**DEVIATION REQUEST  
AND DECISION FORM**  
(Judge Orr Deviation)  
Updated: 6/26/2019

Project Name : Monument Ridge East

Deviation No. 3 - Exhibit 1

Figure 3  
Proposed Realignment  
of Monument Hill Rd  
and Extension of  
Misty Acres Blvd

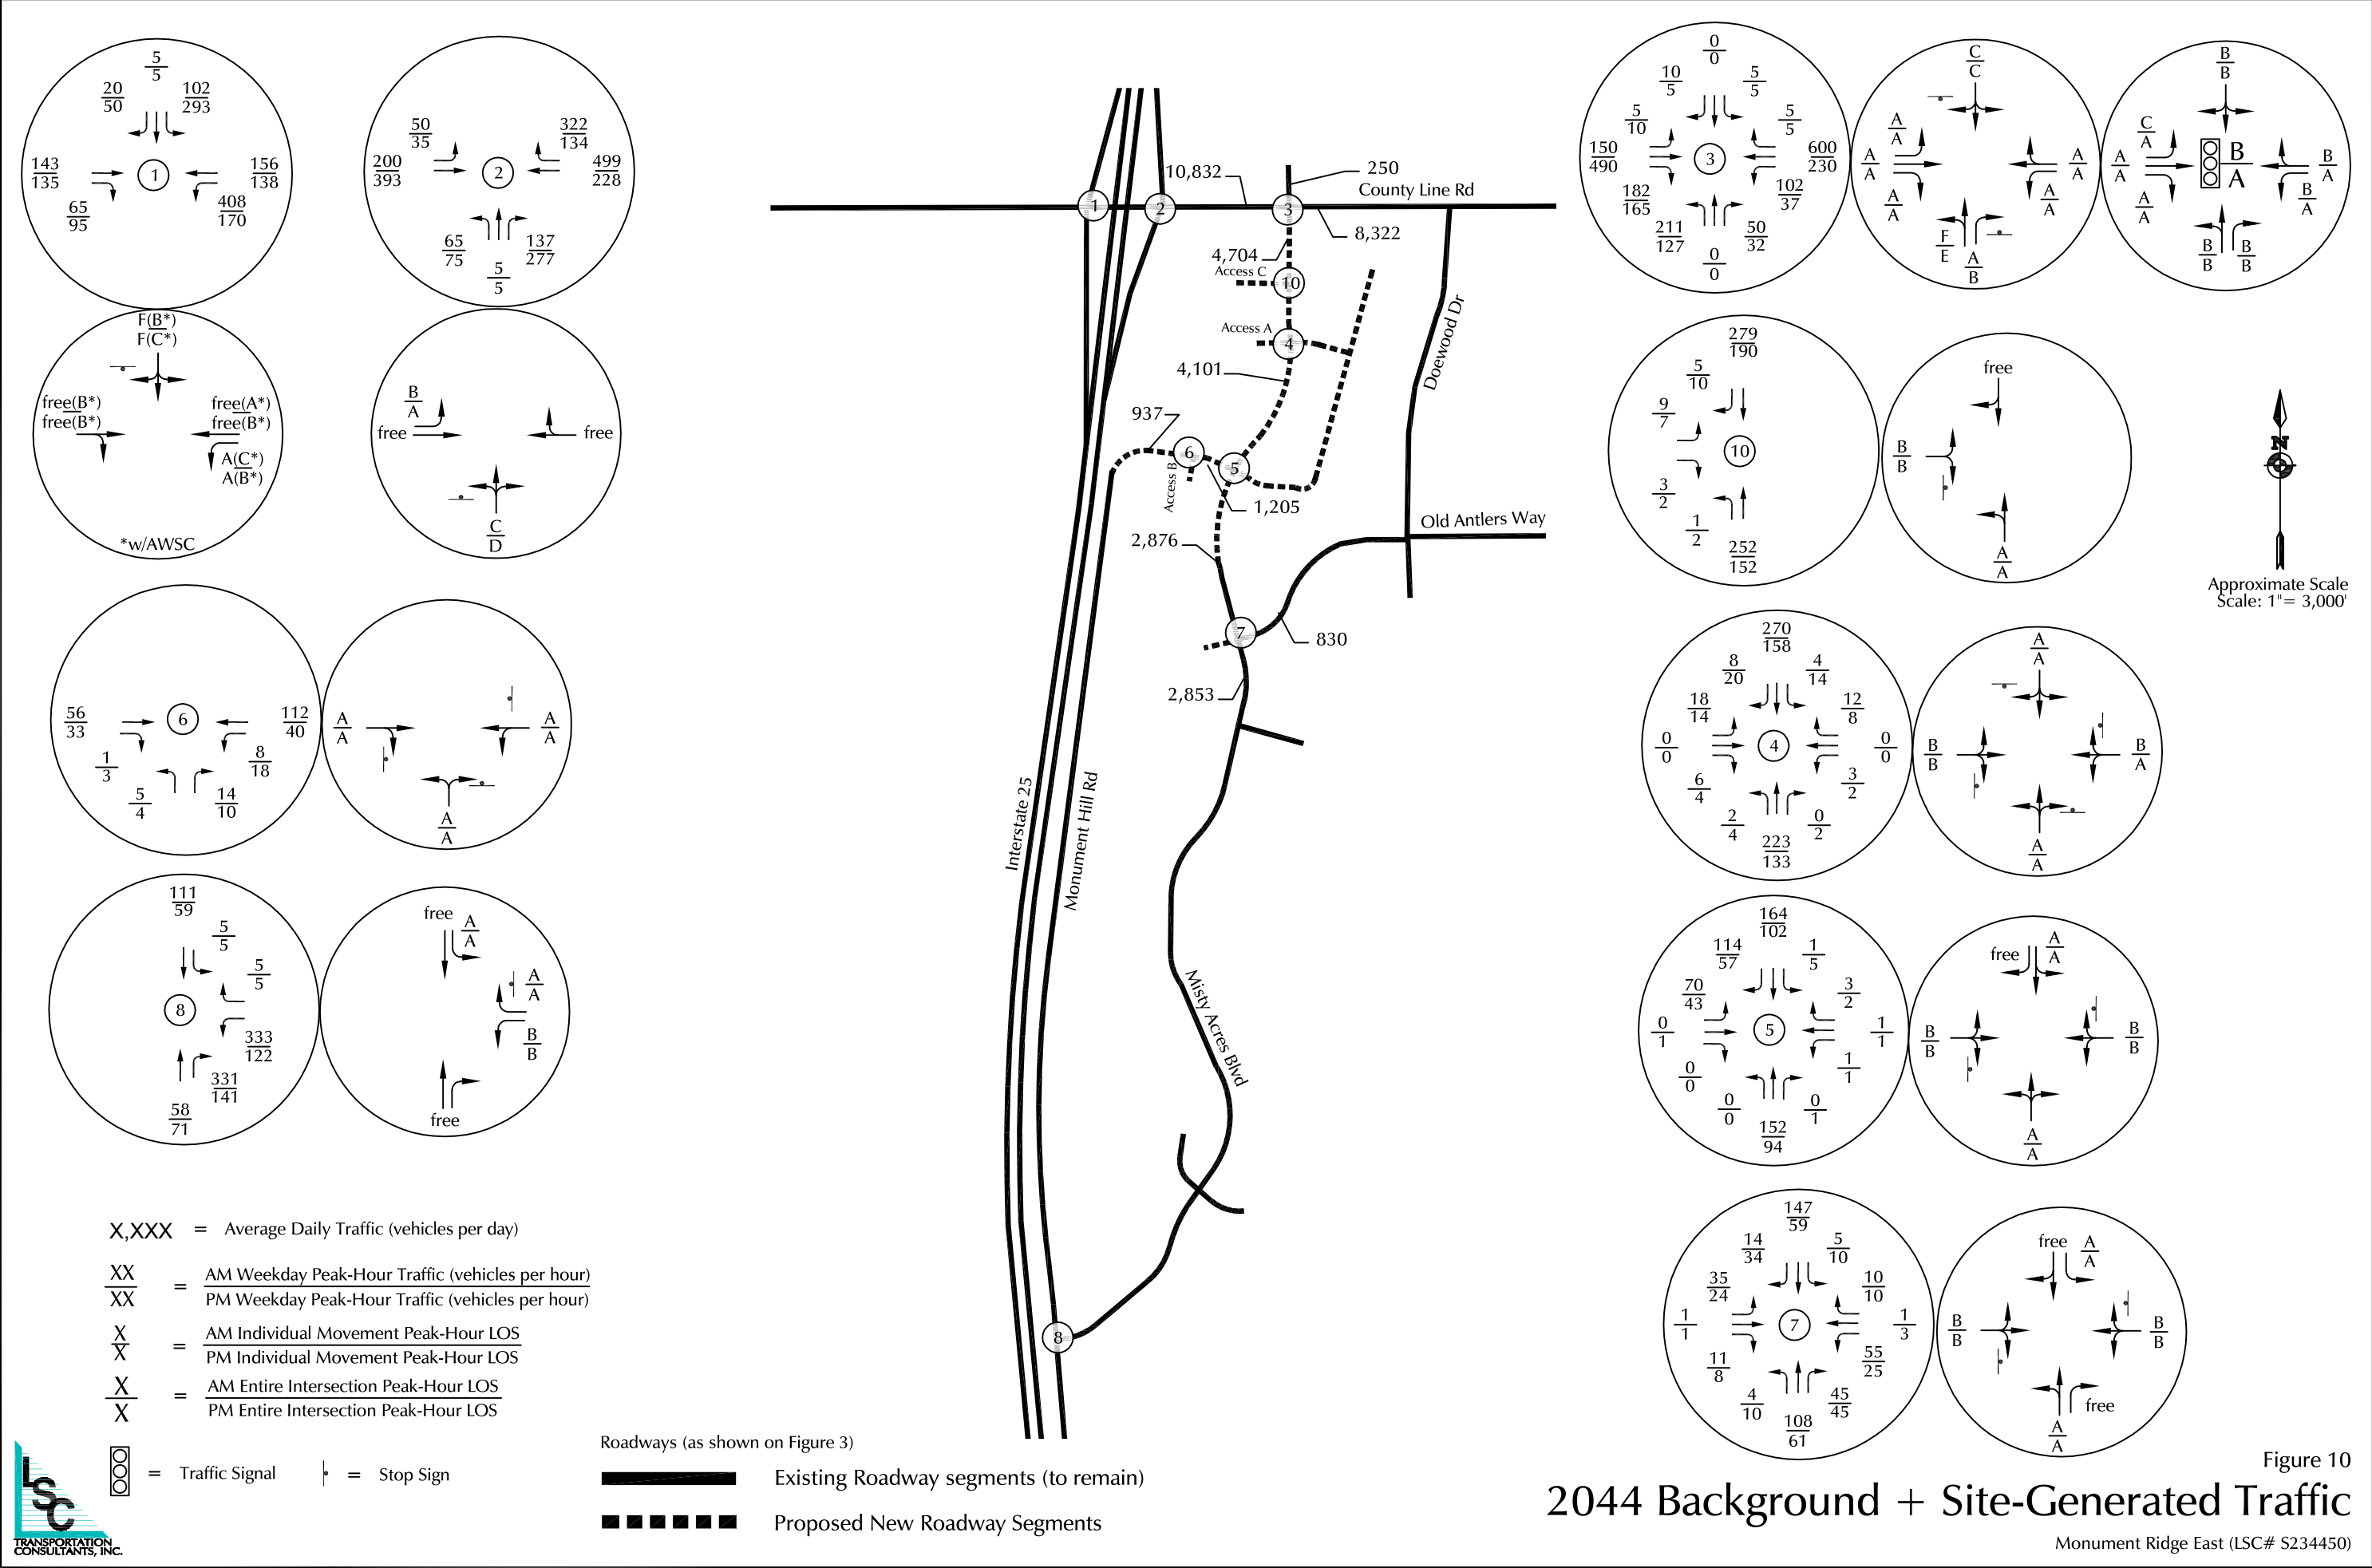
Exhibit 2 is missing

Please add spacing  
from the currently  
proposed location as  
well
